From: Simon Davis
Sent: 15 June 2021 18:31
To: 'philip [REDACTED]'
Cc: 'christopher.best@arun.gov.uk'; Christopher Best
<christopher.best@arun.gov.uk>
Subject: AL/49/21/DOC - Springfield, Hook Lane

Your client contacted me this morning and asked that I provide an update on the application. Therefore, please see the following summary:

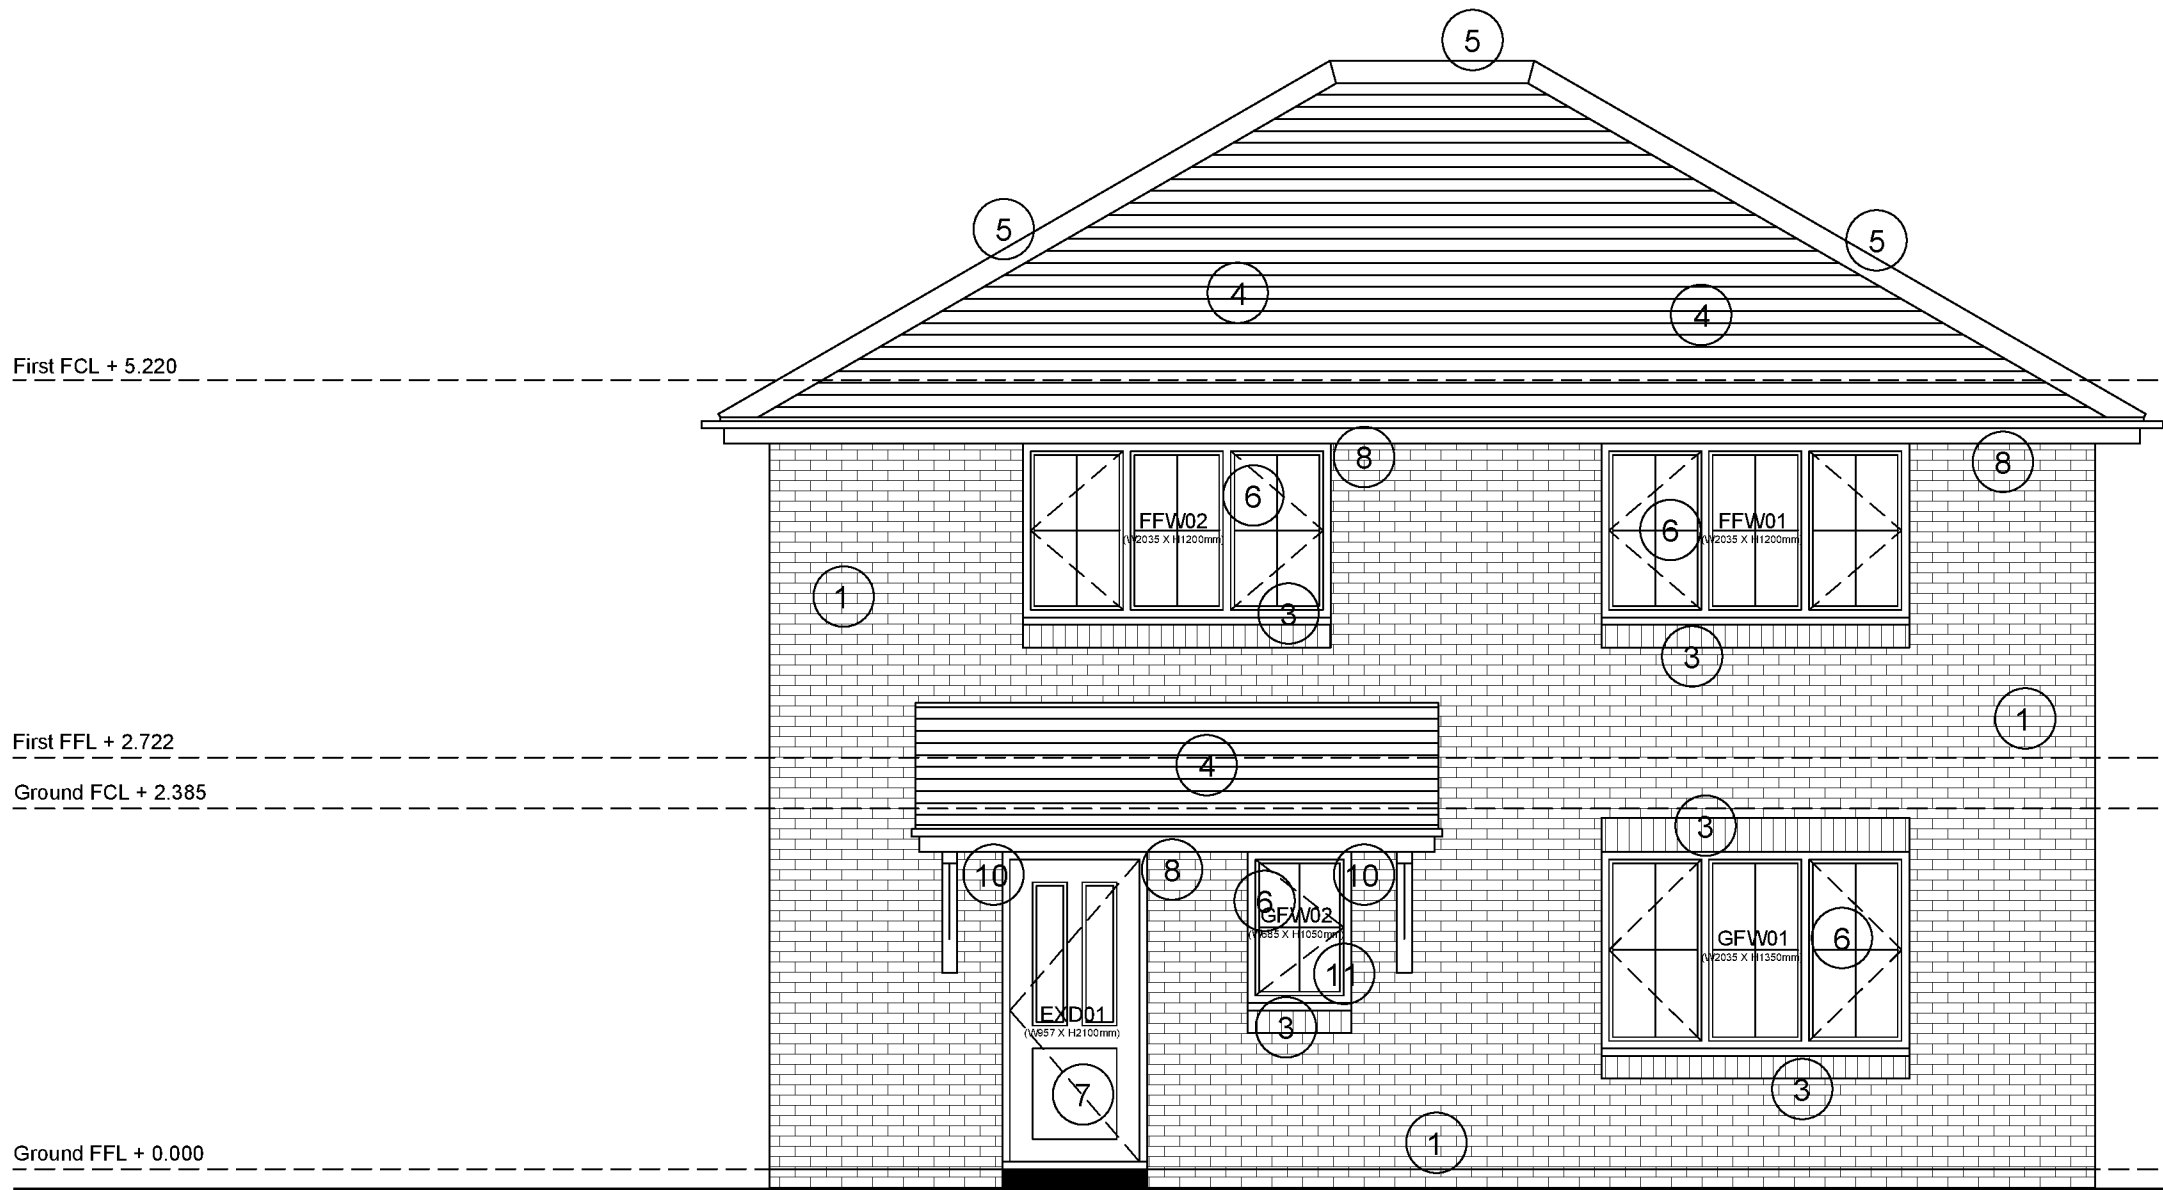
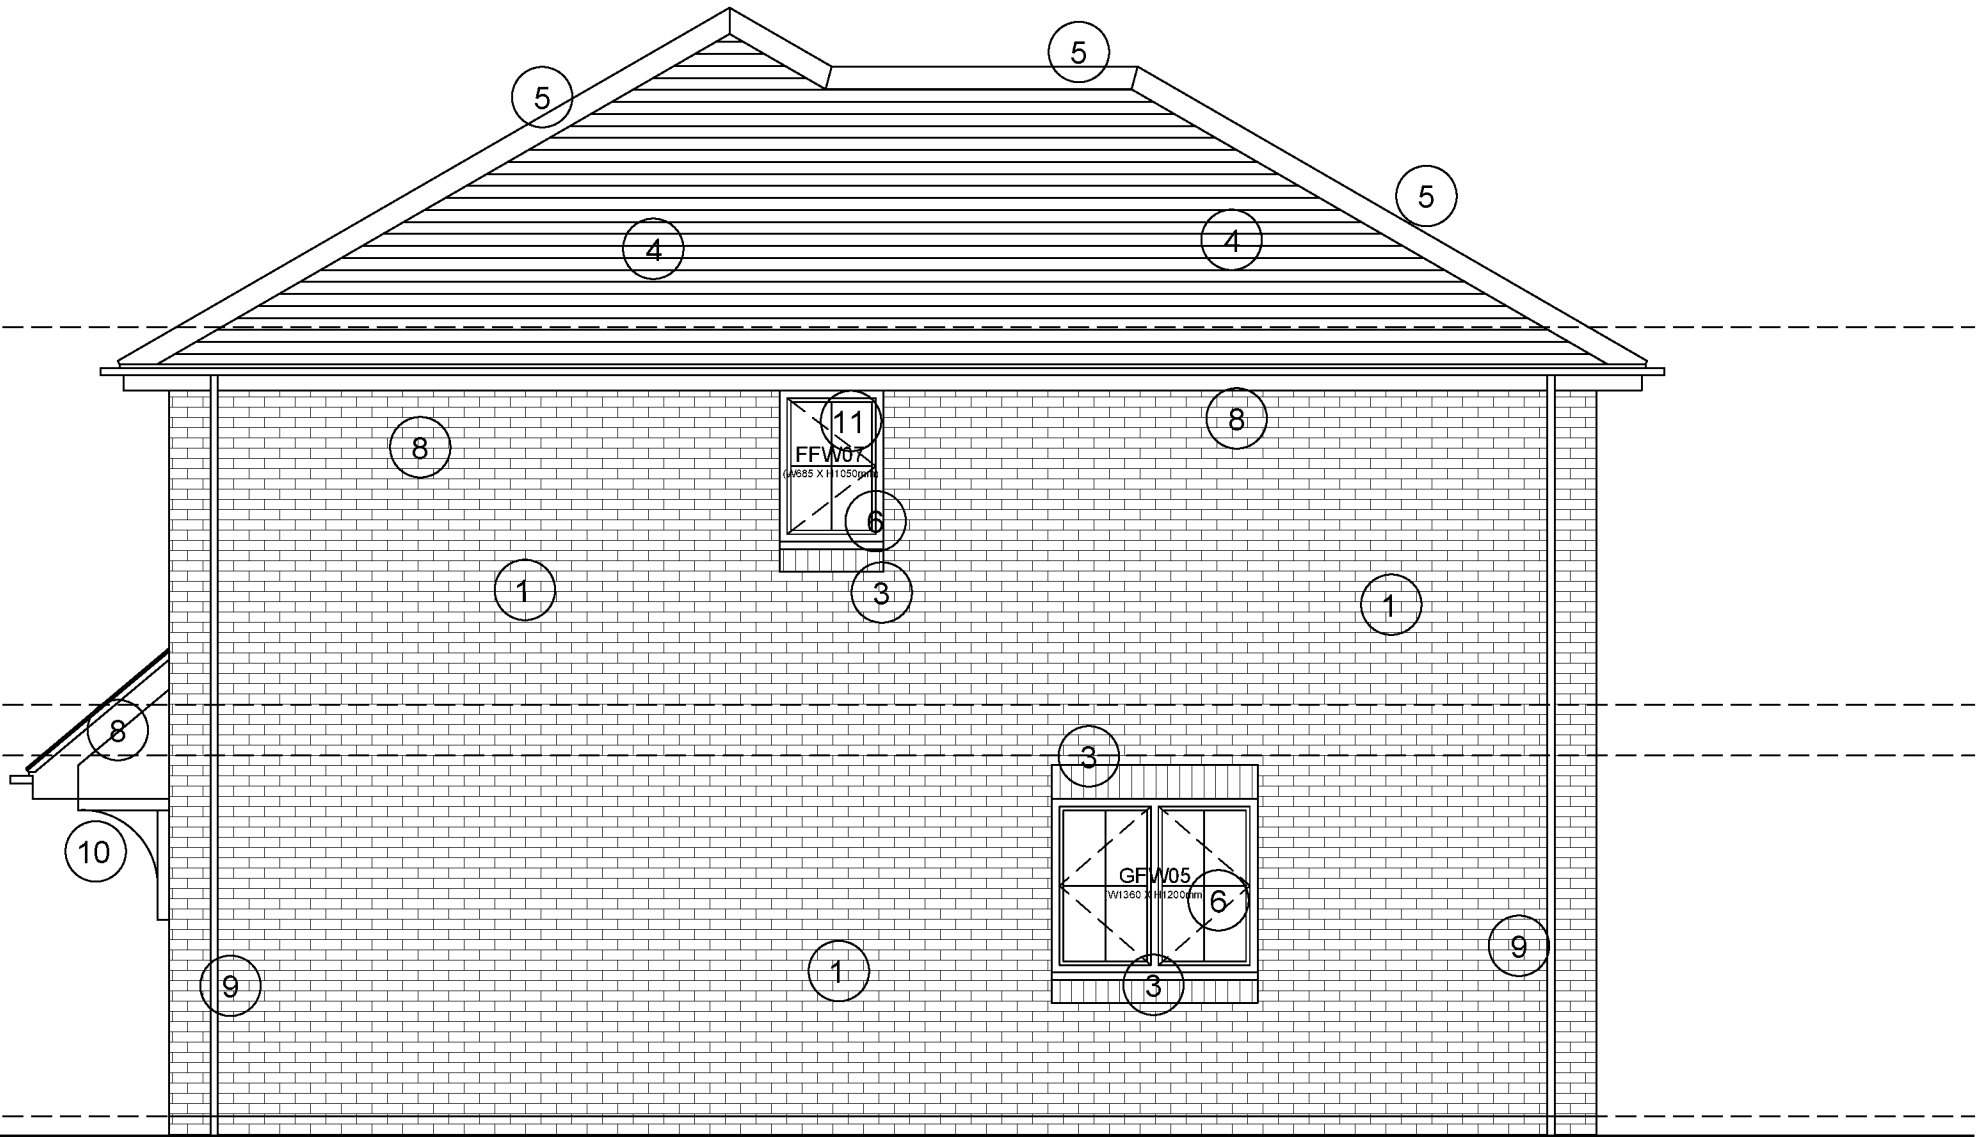
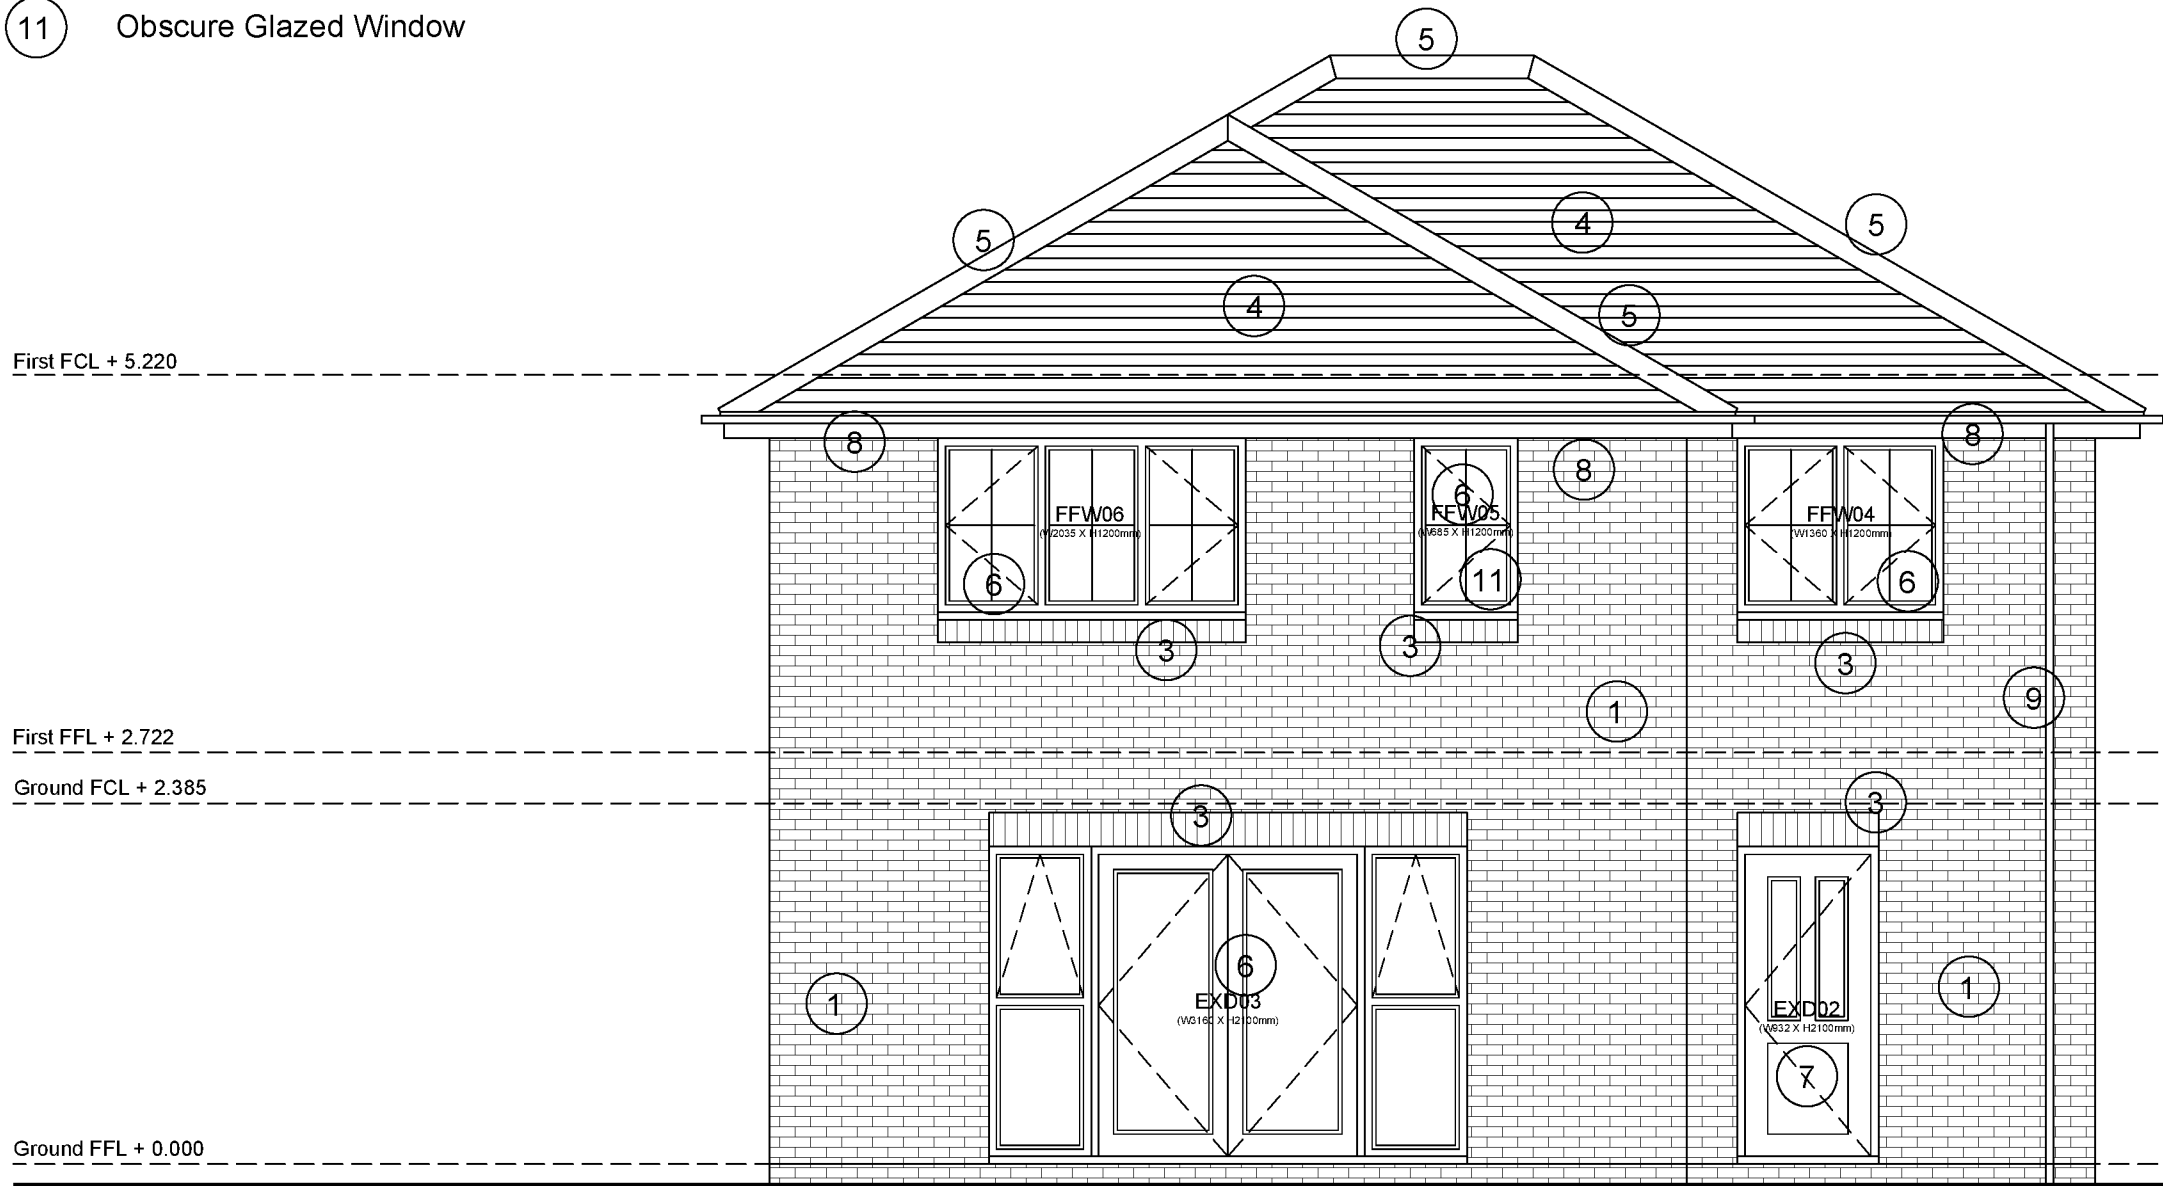
14	I have accepted the amended plans regarding the materials and I will be able to approve this.
15	As 13.
16	I did request that you respond within 10 days of my email dated 07/06 which you did meet. However, I have looked at the condition wording and see that it requires 24 new native trees but the plan provided shows only 12. I will therefore be refusing this condition on the basis of not meeting the condition requirements.
18	The use of Air Source Heat Pumps (as shown in the spec and the associated plan) is acceptable but there is no information to meet this part of the condition “.. <i>demonstrate that the development will achieve energy efficiency measures that reflect the current standards applicable at the time of submission ...</i> ” It is not appropriate to just propose
